Supporting Document Summary

Proposal Name	97 SGD
Reference	PP-12667206
Version Number	1
Submission Date	12/12/2023
Attachments

Project	Flat 1 Extension @ 97 St George's Drive	
title	Section A-A Winter garden - Proposed	
drwg	0042-GA-01-P-009	date 10/12/23
client	Mikkel Skajem Flat 1 - 97 St George's Drive London SW1V 4DB	rev P 3.0 scale 1:50 @ A3

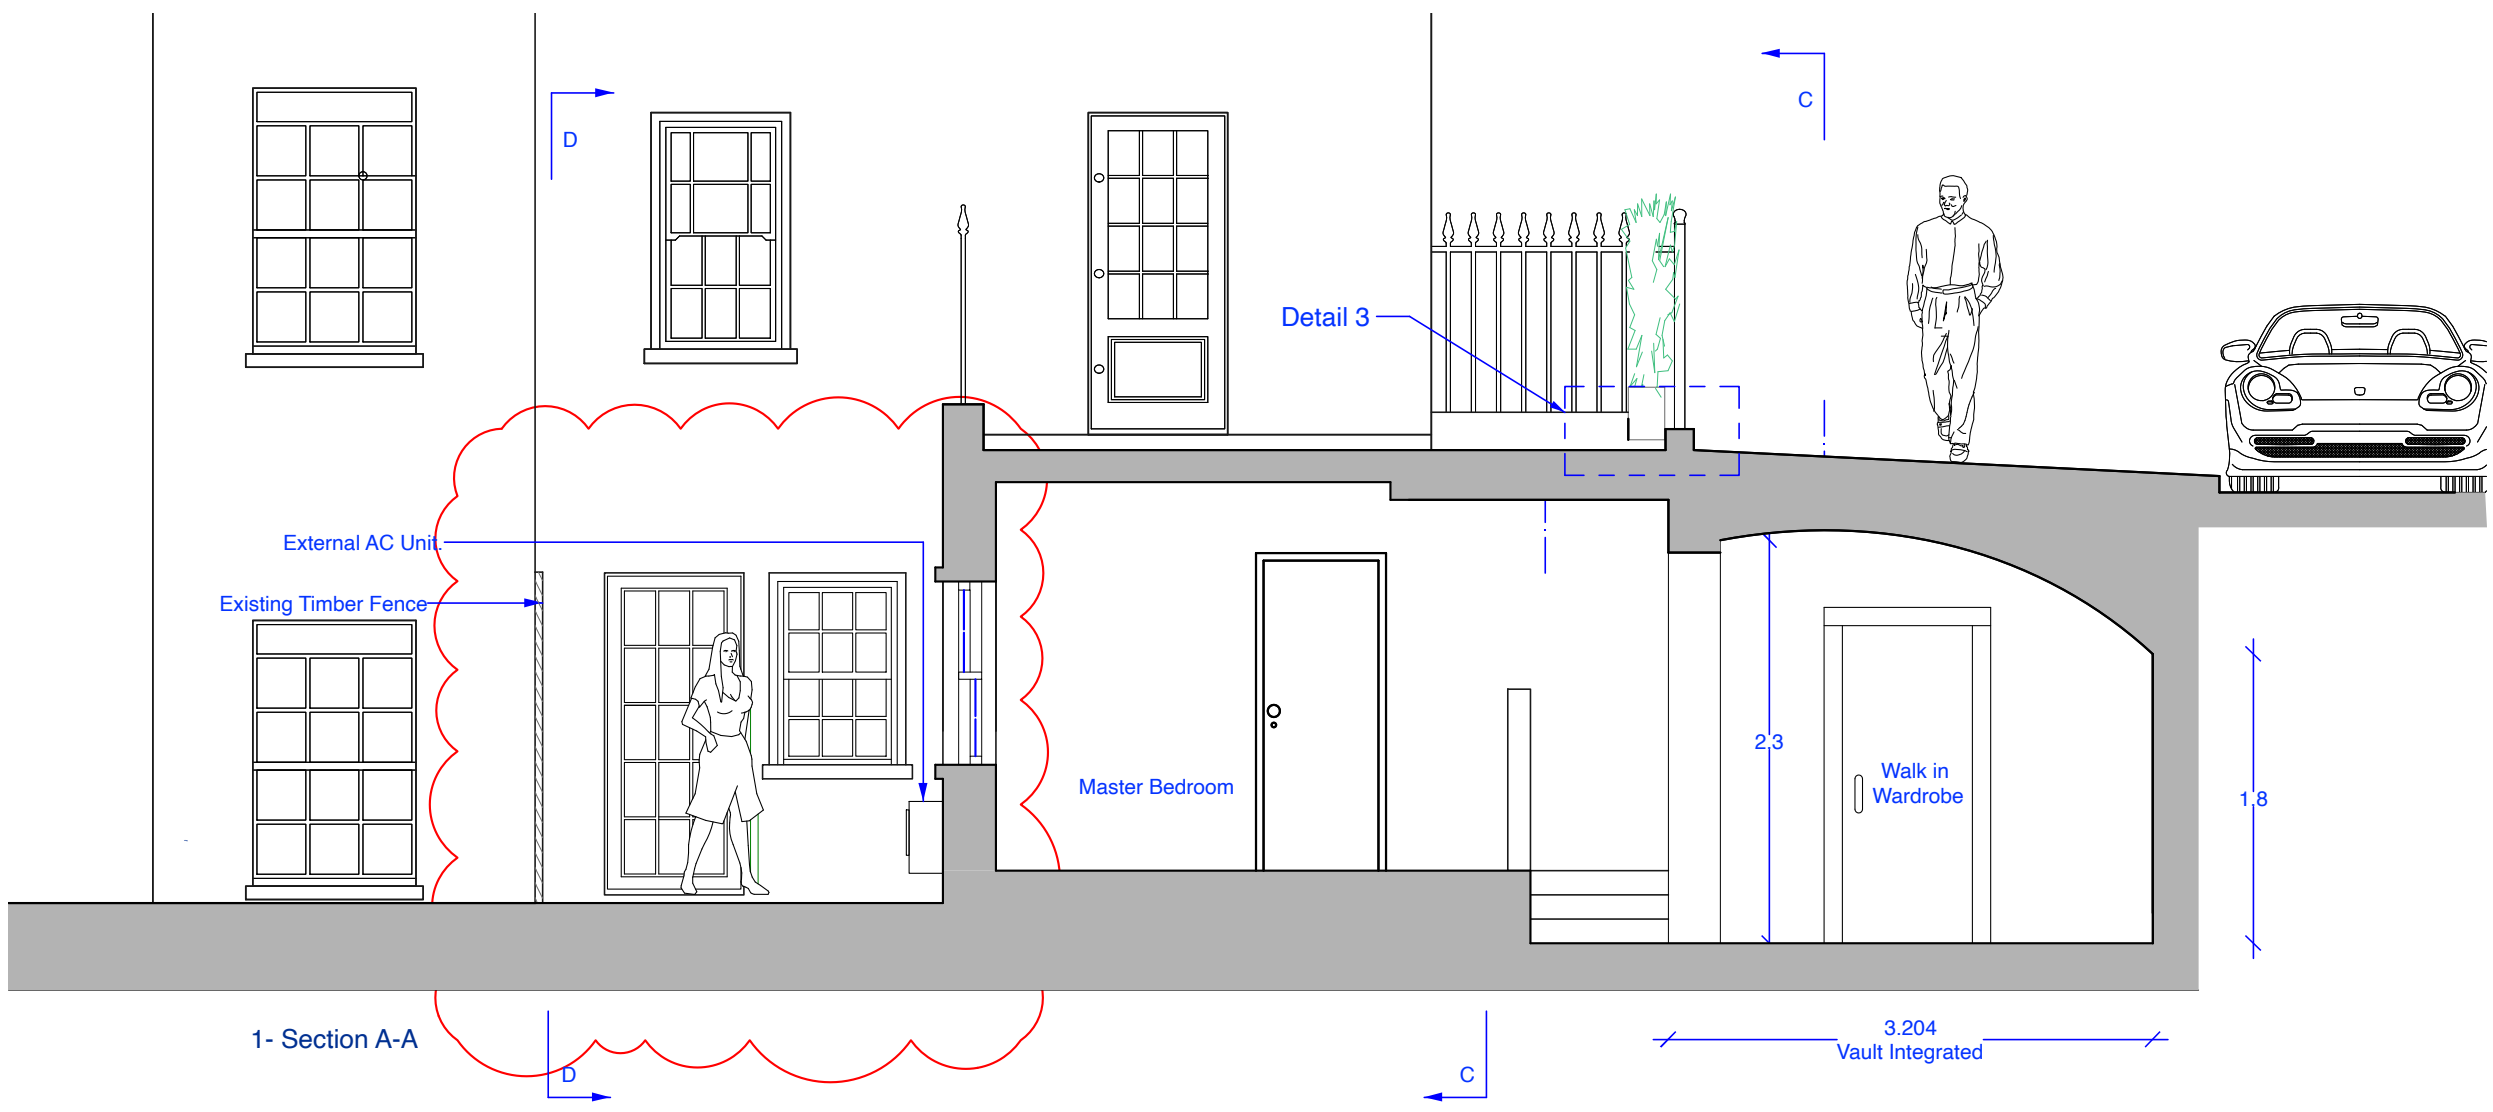
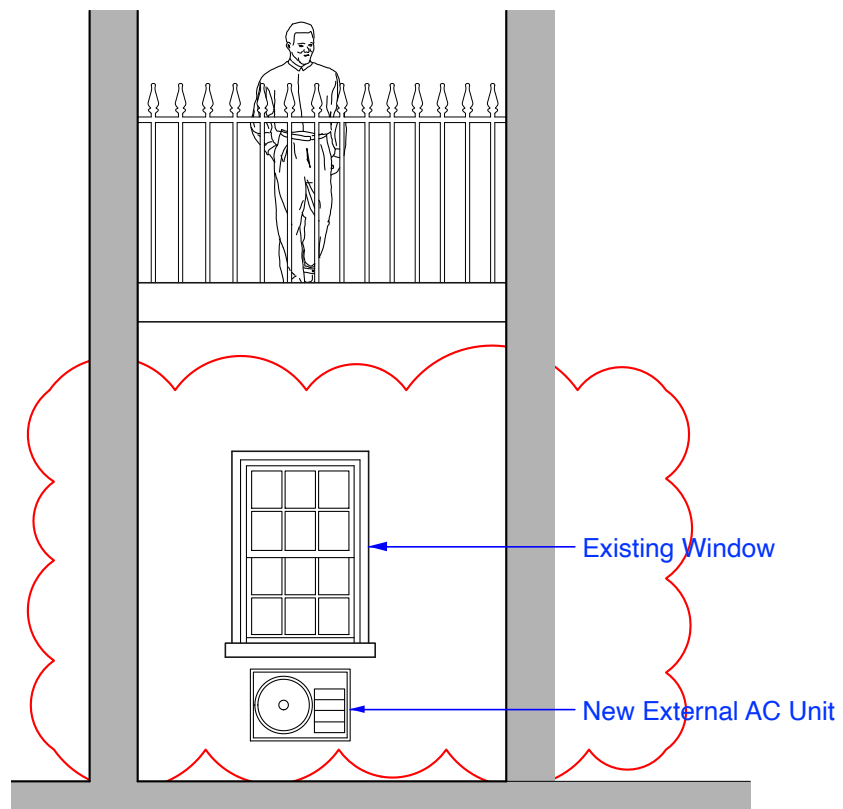
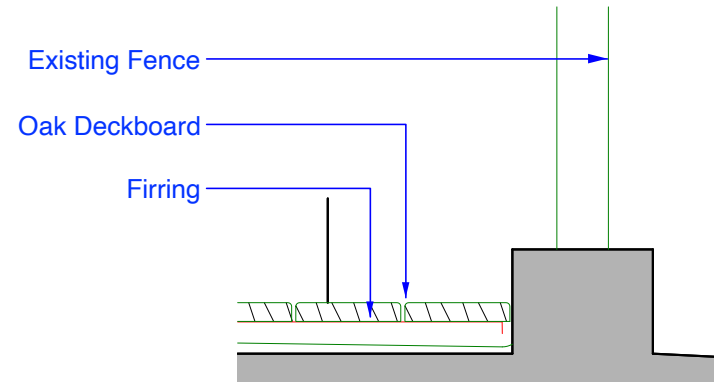
Document Name	Section - Proposed
Document Description	Section A-A (Winter-garden) Proposed. The amendments to this drawing are highlighted by a revision cloud and consist of the omission of the glazed winter garden and the introduction of the air conditioning unit.
Status	New
Submission Date	12/12/2023
Submission Method	Uploaded to storage
File Name	0042-GA-01-P-009.pdf
File Type	application/pdf
File Size (bytes)	174471

Project	Flat 1 Extension @ 97 St George's Drive		
title	Lower Ground Floor Plan - Proposed		
drwg	0042-GA-01-P-008	date	10/12/23
client	Mikkel Skajem Flat 1 - 97 St George's Drive London SW1V 4DB	rev	P 3.0
		scale	1:50 @ A3

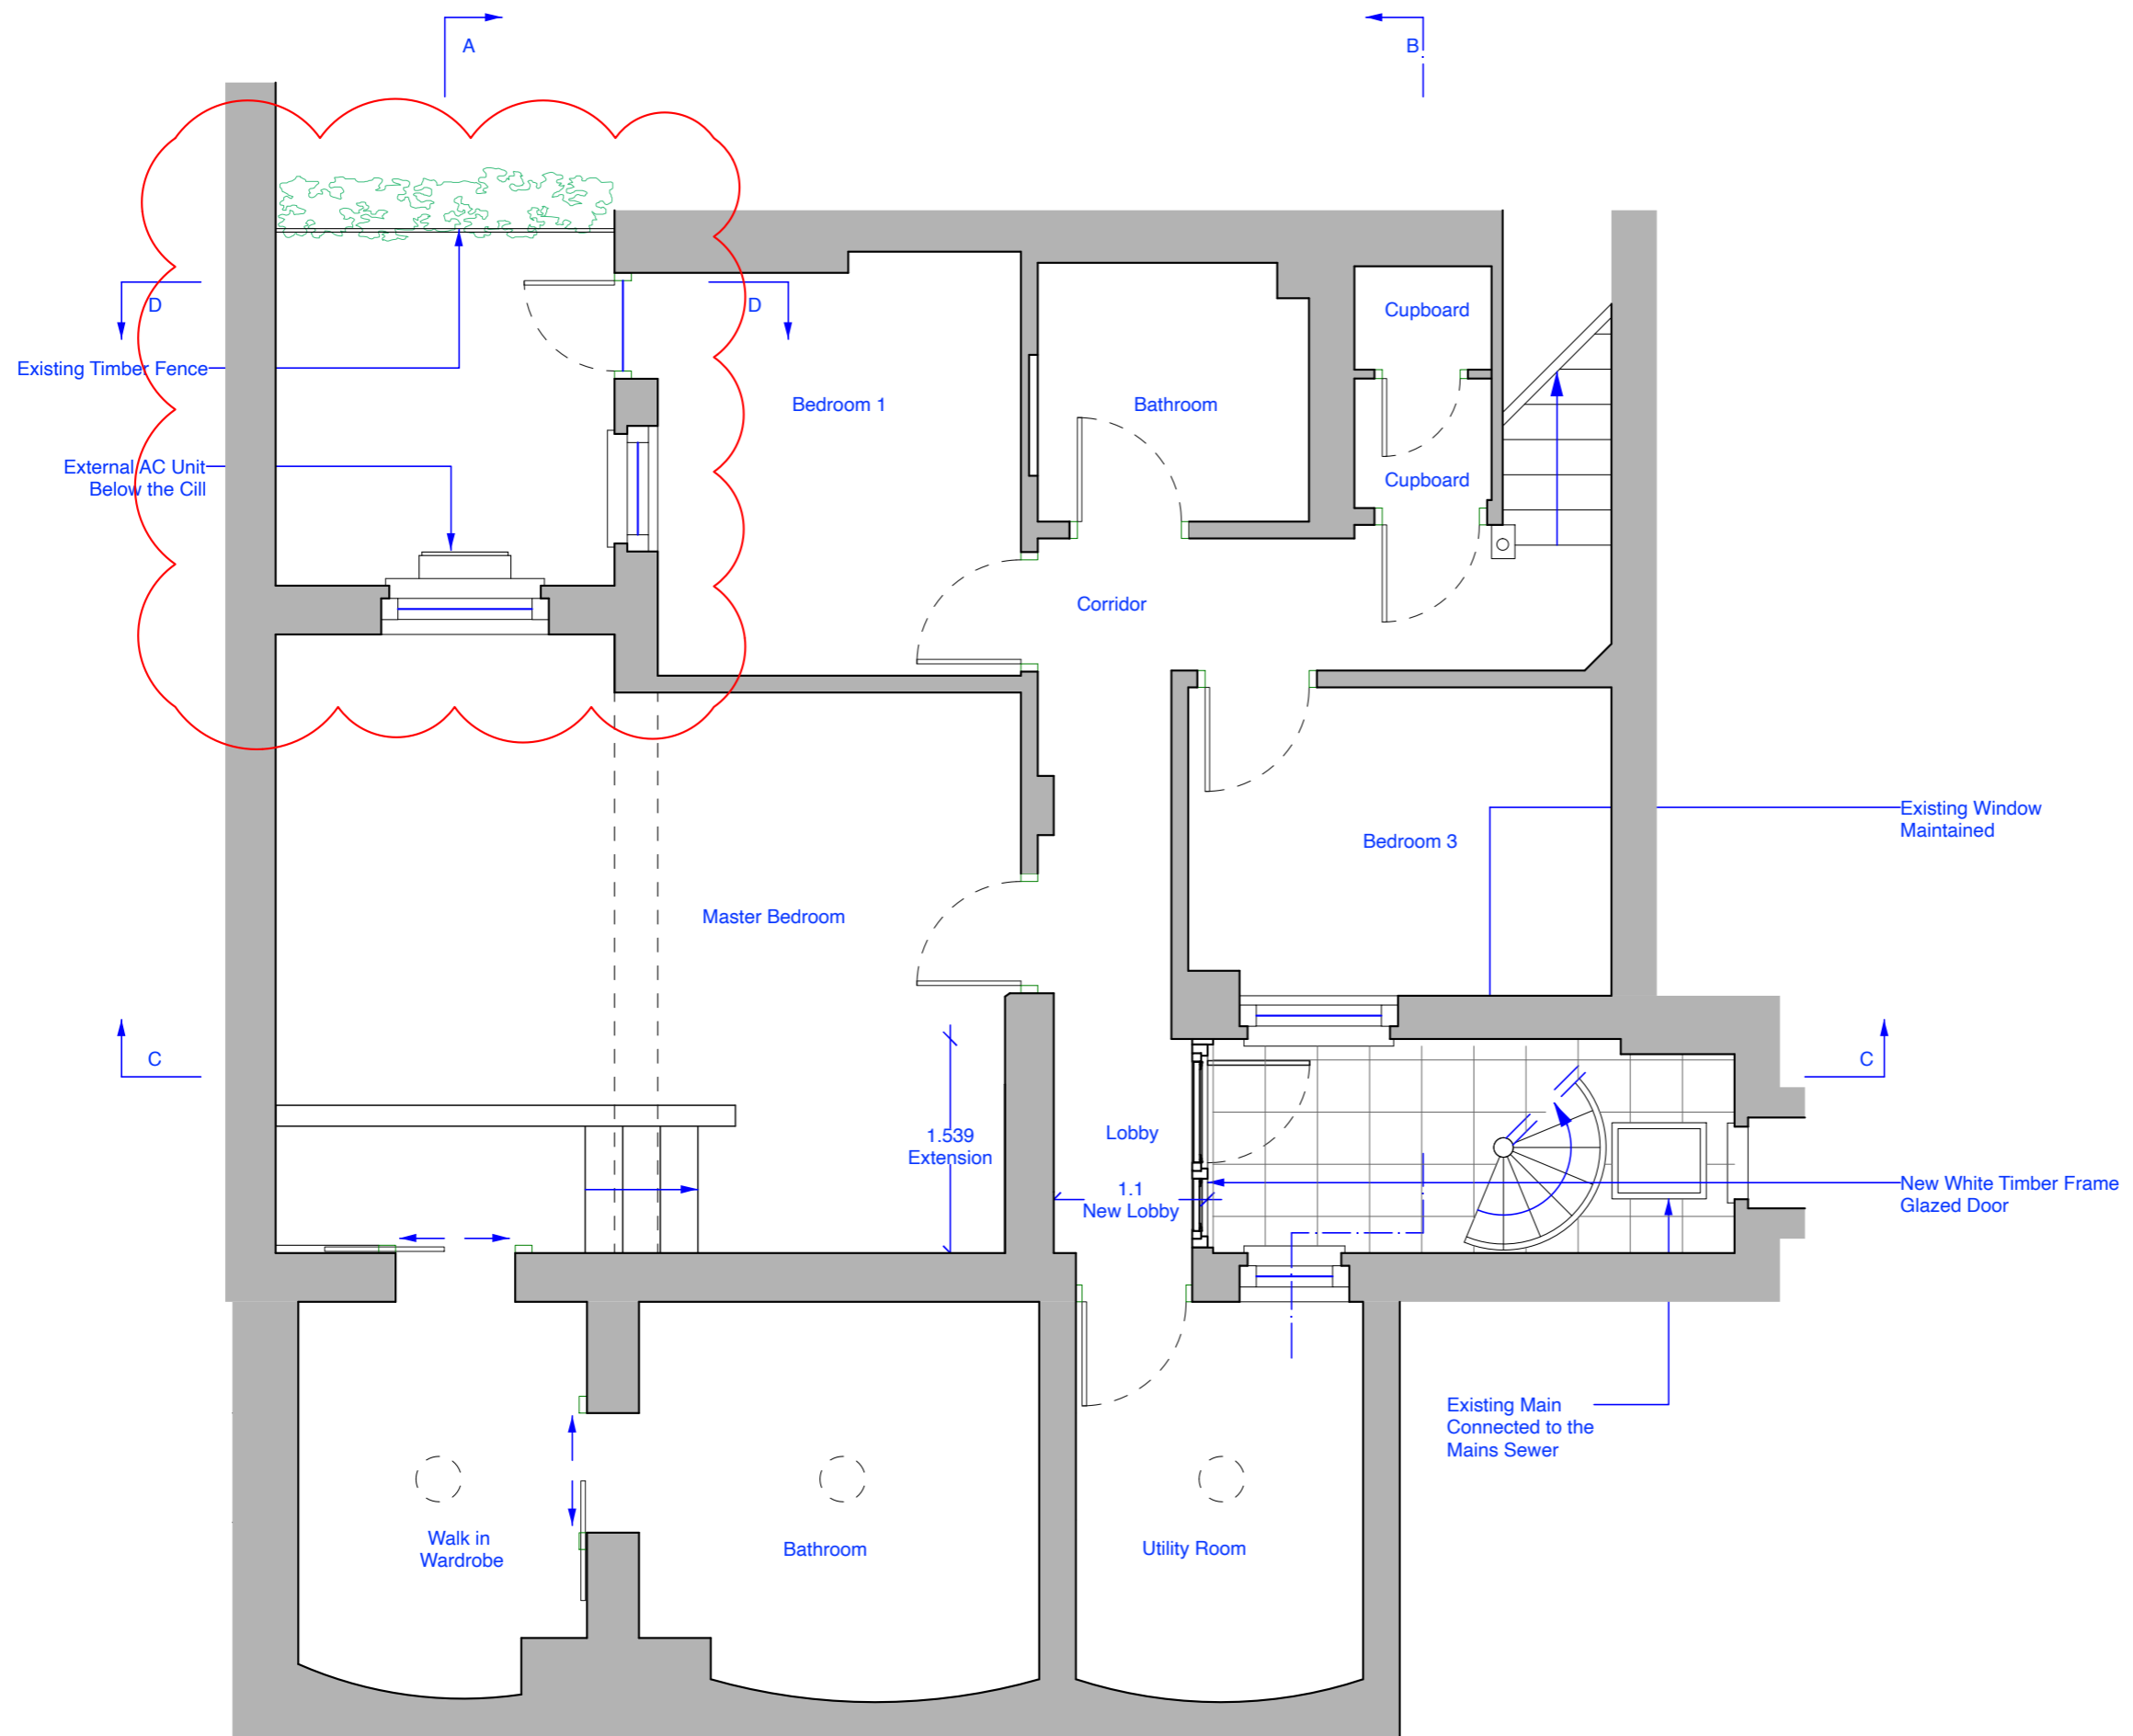
Document Name	Floor plan
Document Description	Basement Plan Proposed. The amendments to this drawing are highlighted by a revision cloud and consist of the omission of the previously proposed glazed winter garden and the introduction of the air conditioning unit.
Status	New
Submission Date	12/12/2023
Submission Method	Uploaded to storage
File Name	0042-GA-01-P-008.pdf
File Type	application/pdf
File Size (bytes)	100240
